PIKE SOLAR GRADING, EROSION & SEDIMENT CONTROL PLANS

EPC STORMWATER REVIEW COMMENTS ARE SHOWN IN ORANGE BOXES WITH BLACK TEXT

PCD-ENGINEERING REVIEW COMMENTS IN BLUE BOXES WITH BLUE TEXT

PIKE SOLAR
EL PASO COUNTY, COLORADO
GRADING & EROSION CONTROL PLANS
COVER SHEET

PIKE SOLAR
EL PASO COUNTY, COLORADO
GRADING & EROSION CONTROL PLANS
INITIAL (3 OF 24)

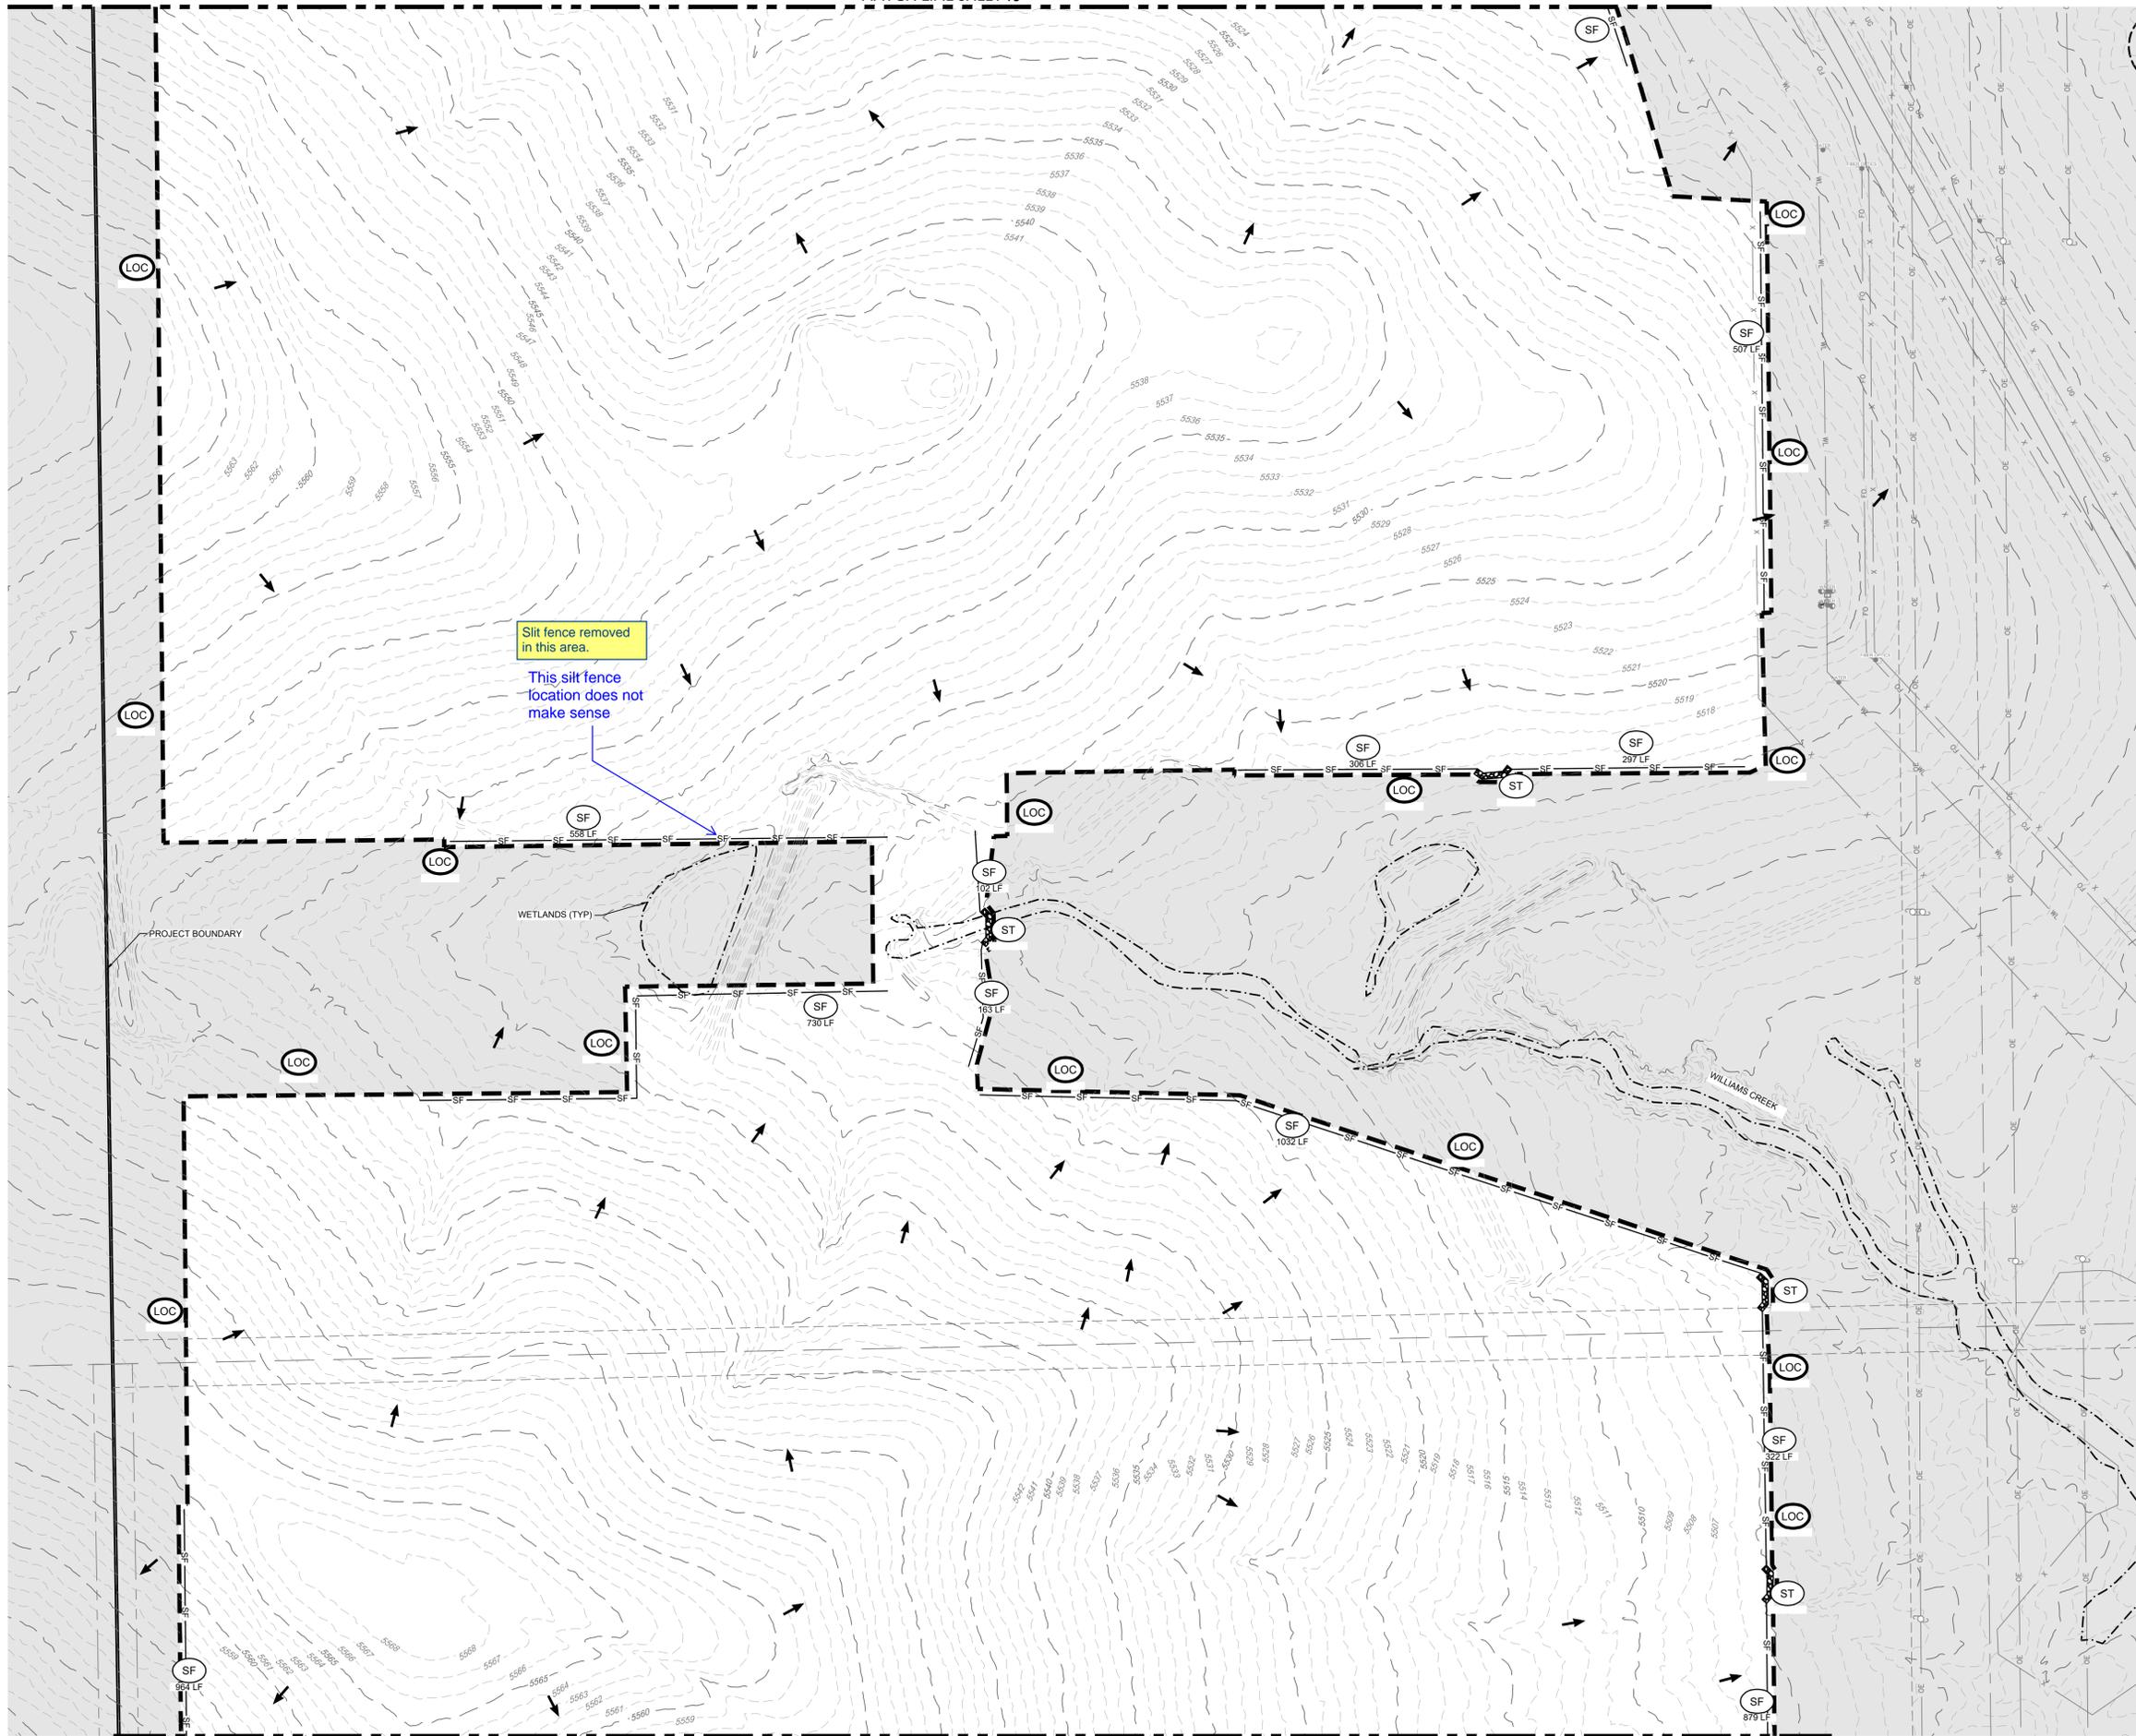
Sediment traps are not appropriate for this application. Temporary sediment basins should be used for tributaries greater than 1 ac. (typ.)

JOB NO.
20-194
SHEET
33 OF 77

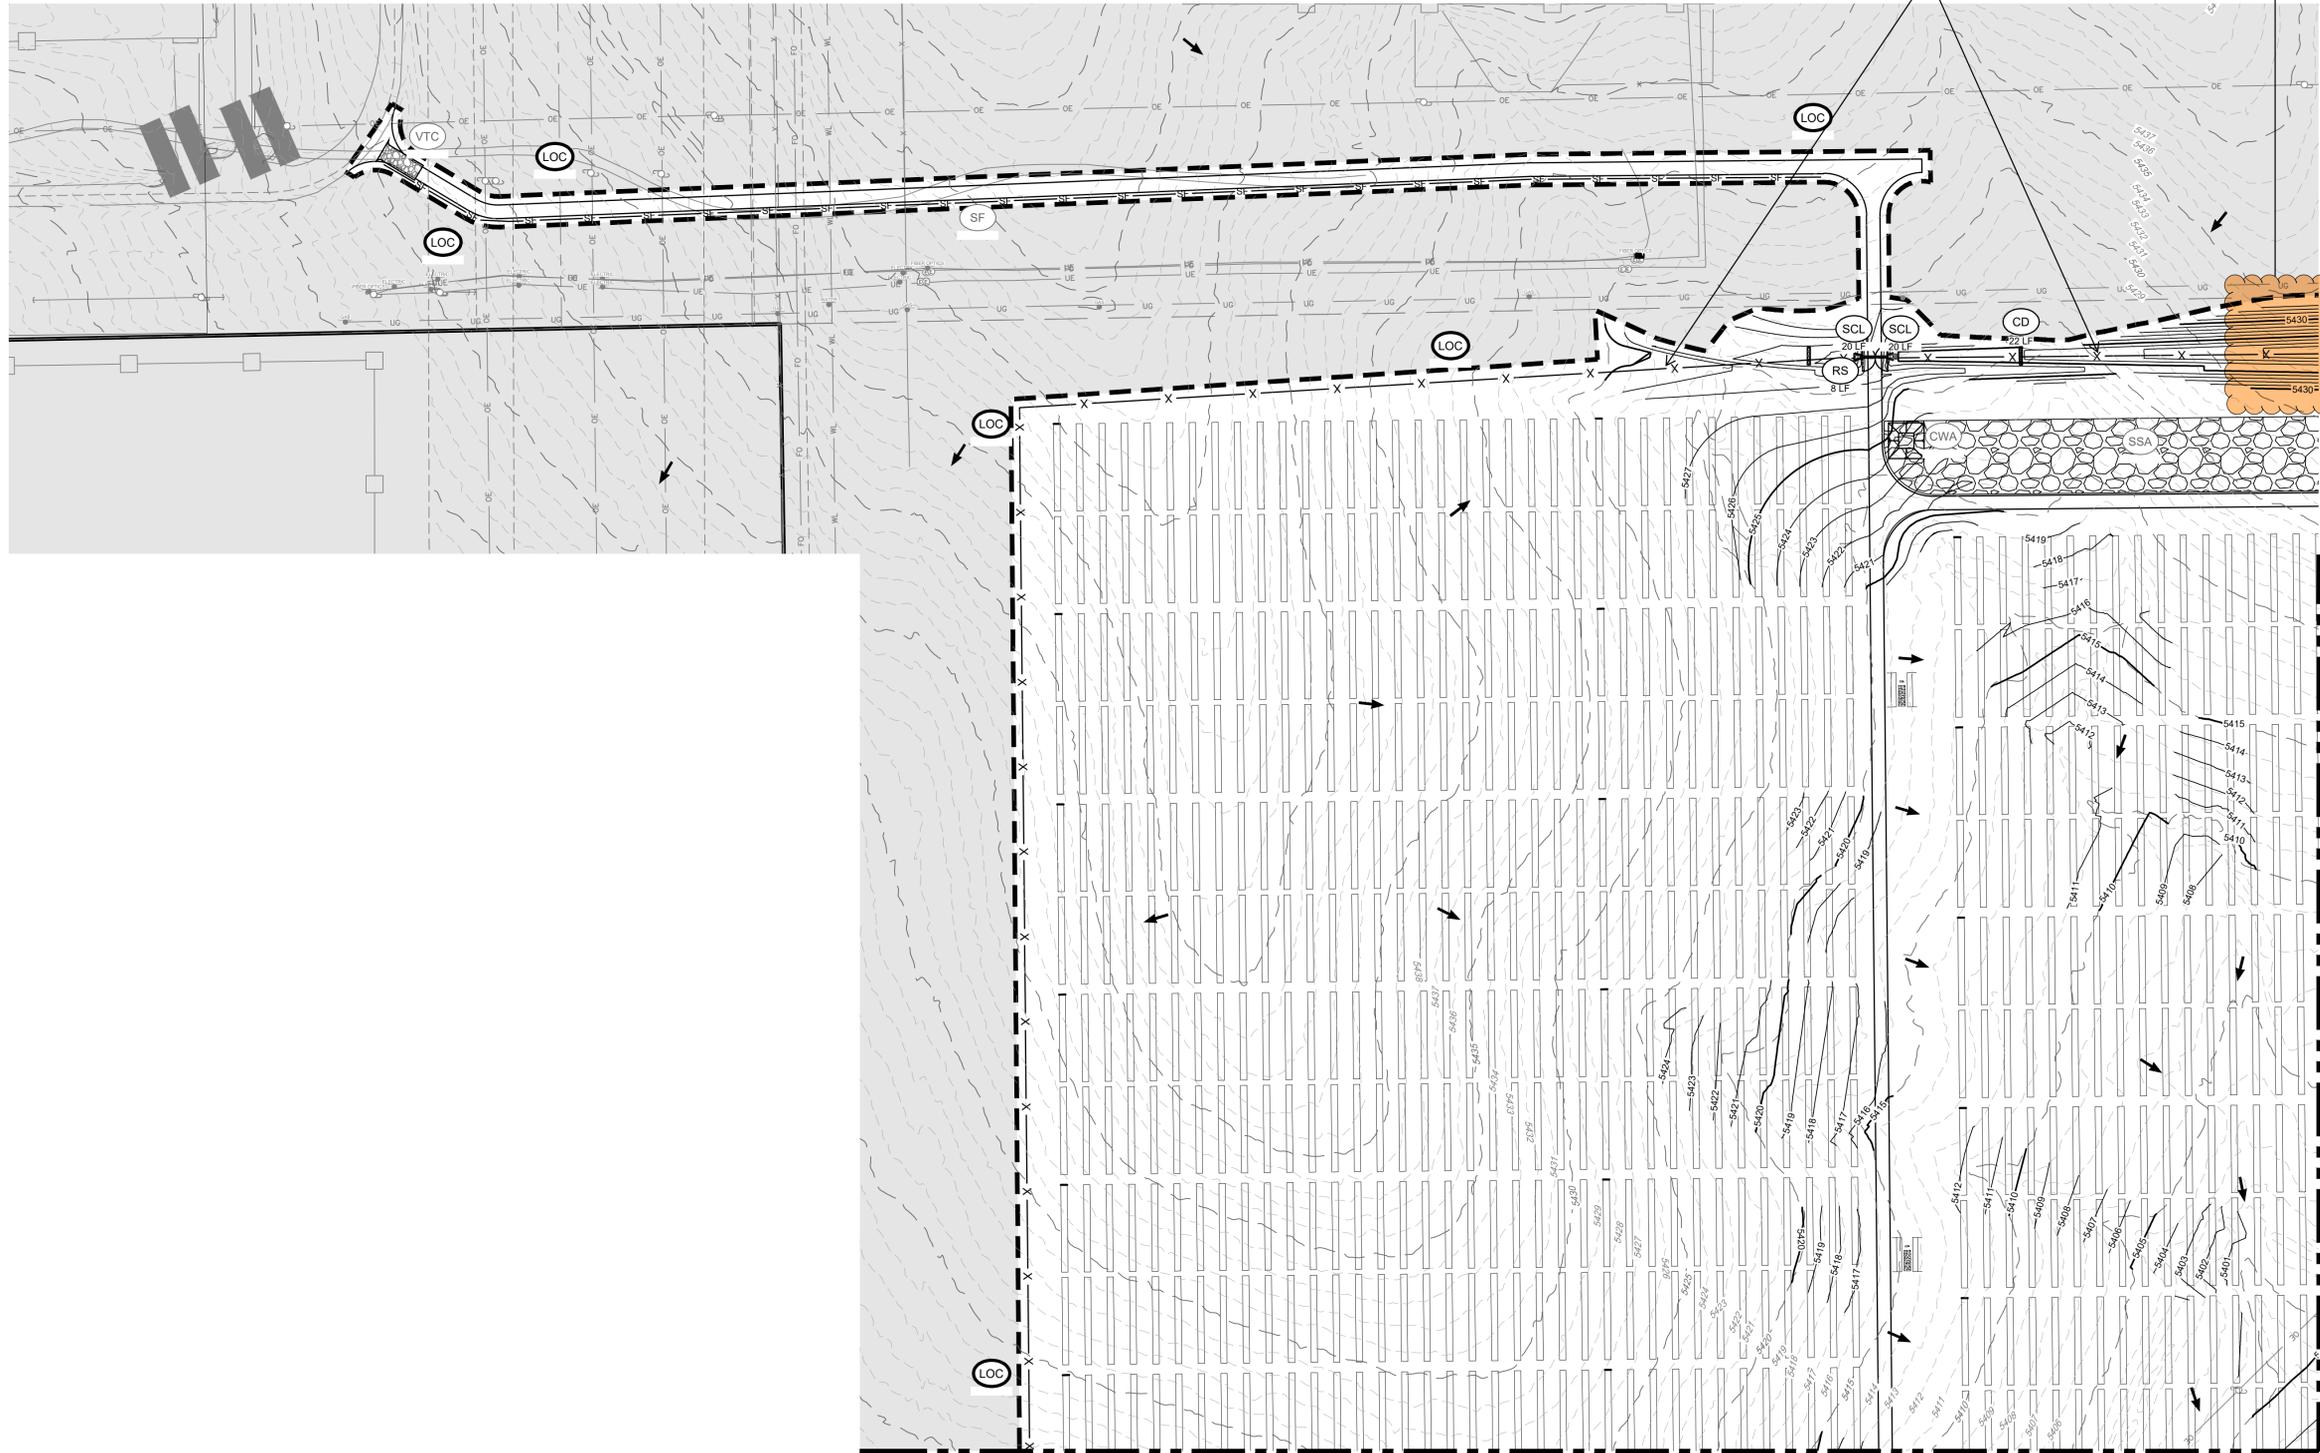
Silt fence with J-hooks? (flow along silt fence is going to be channelized)

JOB NO.
20-194
 SHEET
46 OF 77

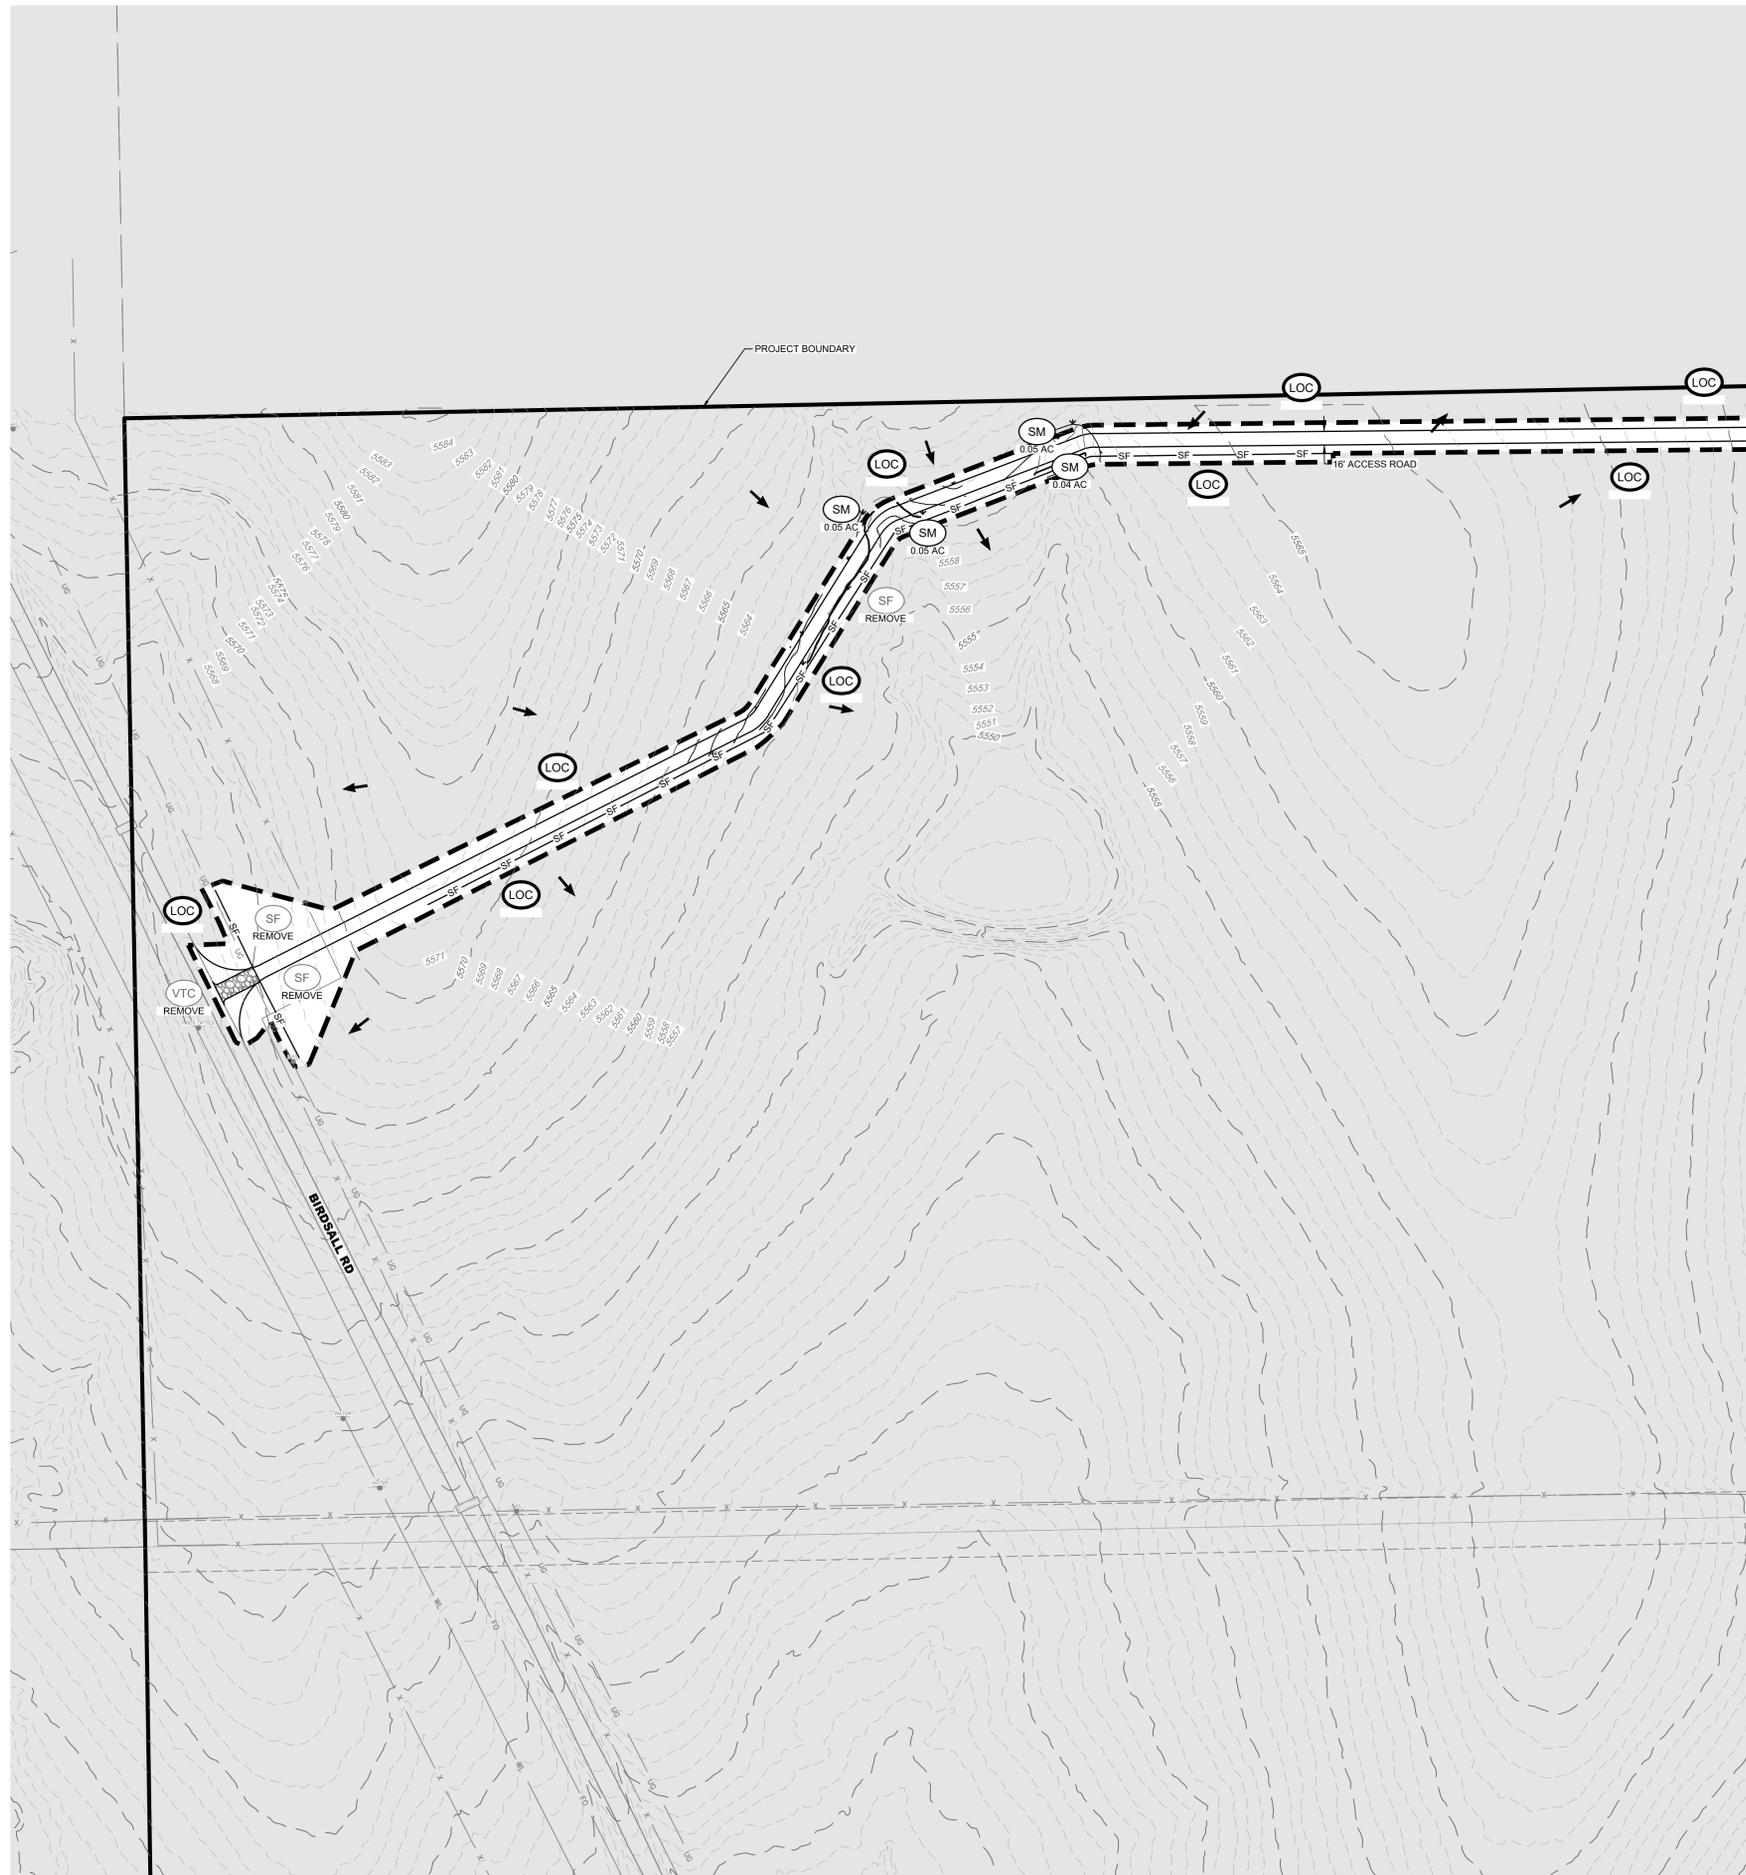
Do not show temporary BMPs on Final sheets or make symbols on sheets gray like text

show permanent seeding/mulching areas, areas to be paved, gravel areas to remain, etc. with hatching
